**Consultation Response from KC,  
Highways Development Management****2024/92341 3, Lockwood Scar, Lockwood, Huddersfield, HD4 6BL****Alterations to dwelling to form 2 flats and 3 bed House in Multiple Occupation (Listed Building)****Date Responded: 14/11/2024.****Responding Officer: D. Stainsby****Responding Ref: K6-6SE/41**

This application is for alterations to dwelling to form 2 flats and 3 bed house in multiple occupation at 3 Lockwood Scar, Lockwood.

Existing Block Plan

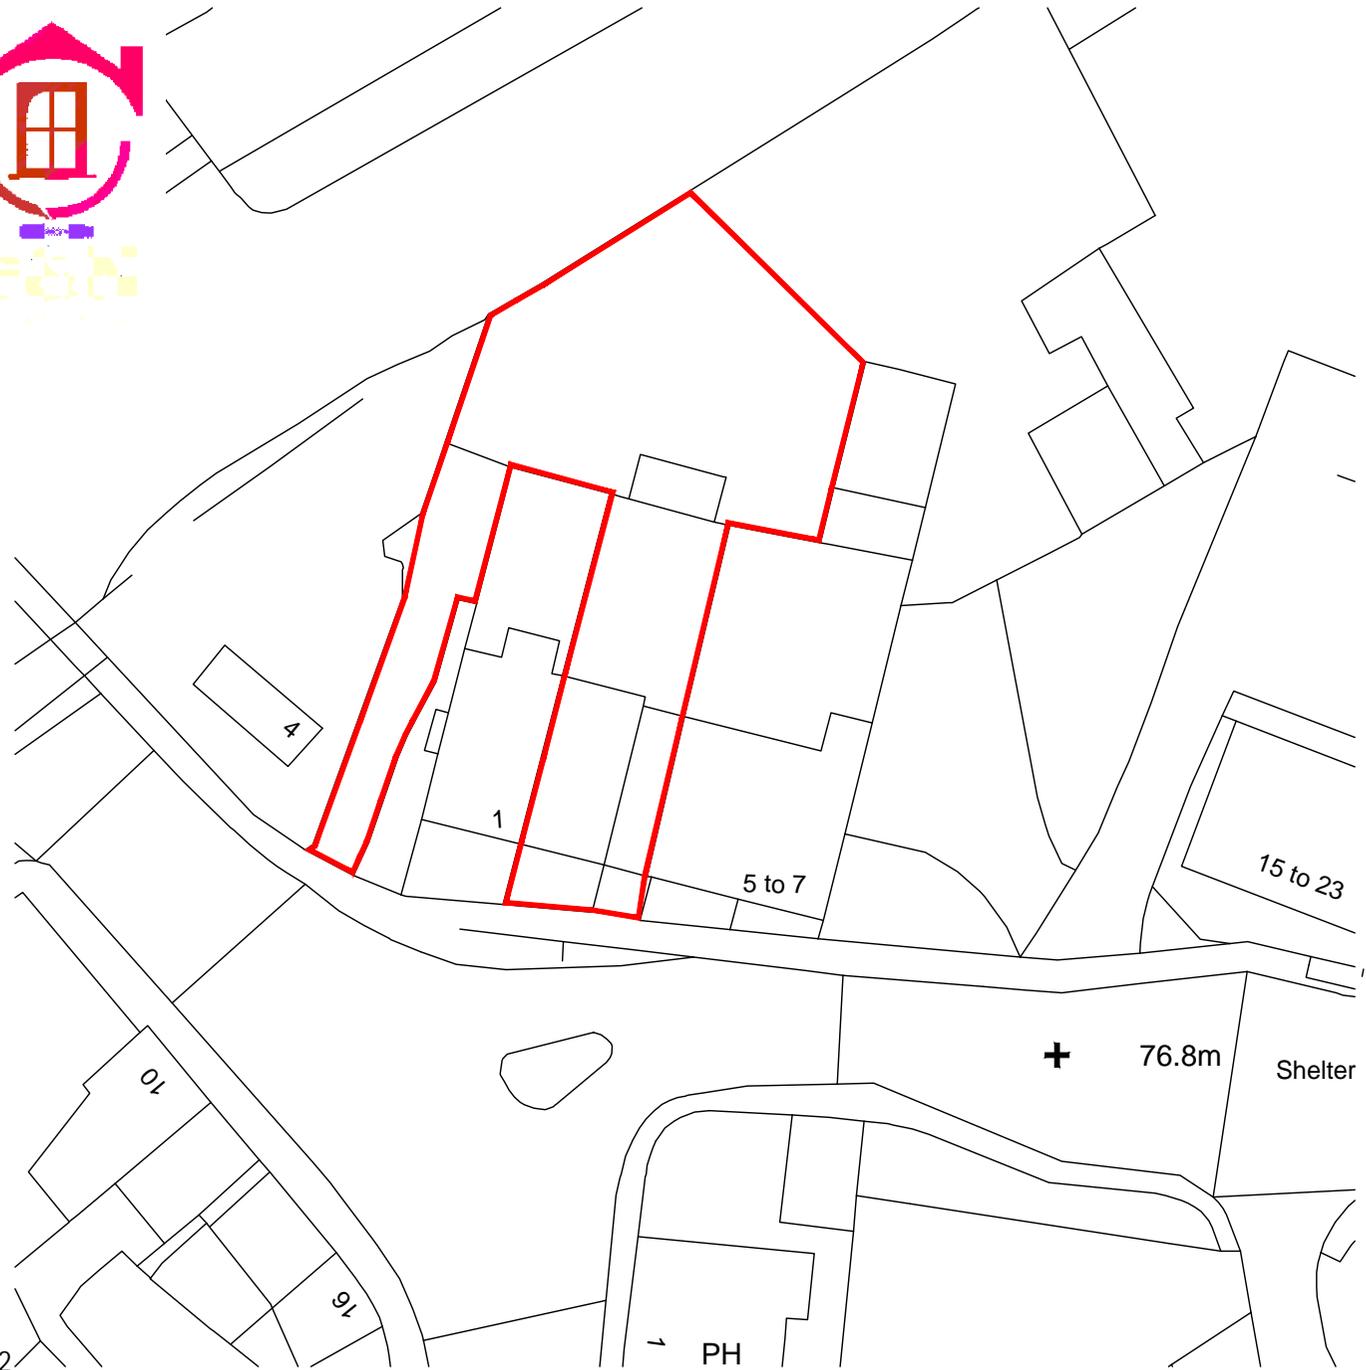
The use of the existing access is acceptable. However, no details have been provided for the car parking area or the secure cycle parking.

A revised drawing showing a car park layout in the rear area is required. The revised drawing will need to demonstrate that 4 vehicles, as stated, can access the area, park and turn to leave the site in forward gear.

The revised plan will need to include the location and details of the cycle storage

No bin storage areas are shown. A bin collection/presentation point should be located adjacent to the public highway. The bin collection/presentation point must not obstruct the adopted highway or the access road.

Details of waste storage and collection should be provided, with the location of a waste collection presentation point being clearly marked on a drawing in such a location that is easily accessible to the collection team and where it will not obstruct the parking, access or the adopted highway for road safety reasons.
